CITY OF ALBUQUERQUE

July 7, 2021

Re: Cottonwood Classical – Portable Addition
7801 Jefferson St NE
Traffic Circulation Layout
Architect's Stamp 05-19-2021 (D17-D003A)

A1 TRAFFIC CIRCULATION LAYOUT

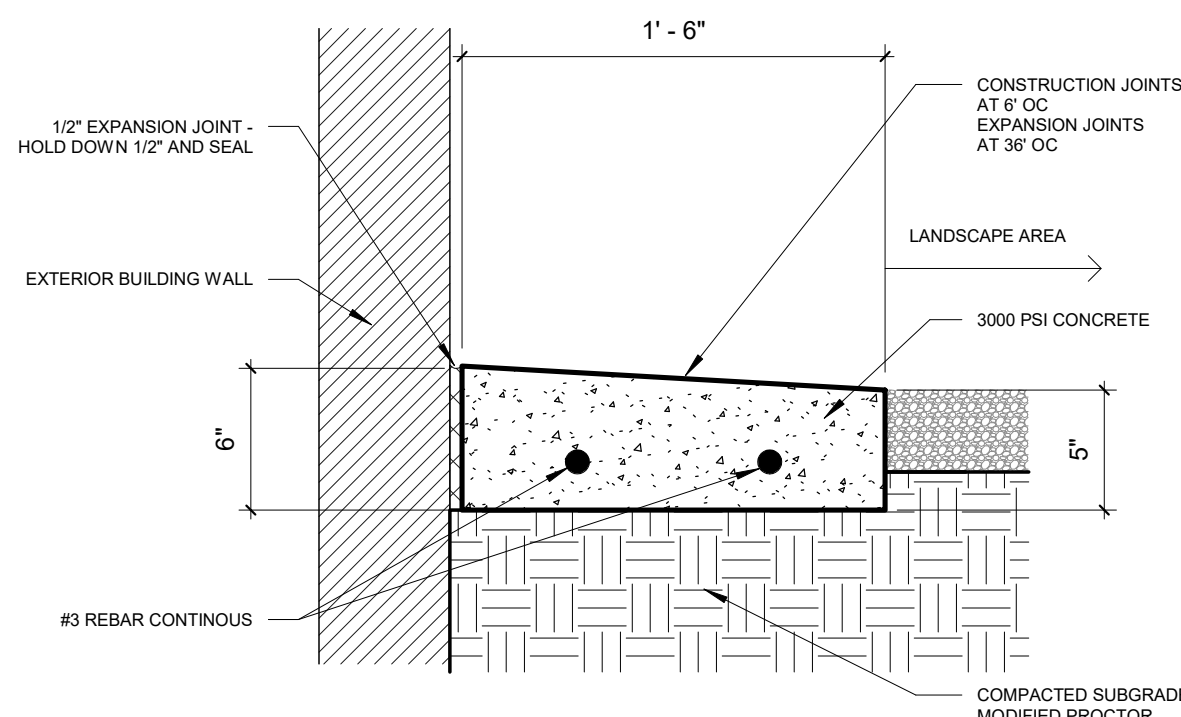
1. The proposed Modular Buildings;

- Does these buildings need parking stalls? Especially ADA parking to service these buildings? Since the existing parking lot has no striping to delineate individual stalls.

Response; 50 yards for the ADA to traverse is unacceptable. (there isn't even a pathway to guide ADA accessible route). Please provide ADA parking stalls in front of Modular Building.

- Provide dimensions for drive aisle leading into existing parking lot. **This comment wasn't responded.**

2. Shared Site acces: driveways that straddle property lines, or are entirely on one property but are to be used by another property, shall have an access easement. Please include a copy of your shared access agreement with the adjacent property owner.

You still need to provided a Shared Site Access.

Parking not needed. 2 ADA parking stall within 50 yards.

Cottonwood Classical owns both adjacent properties.
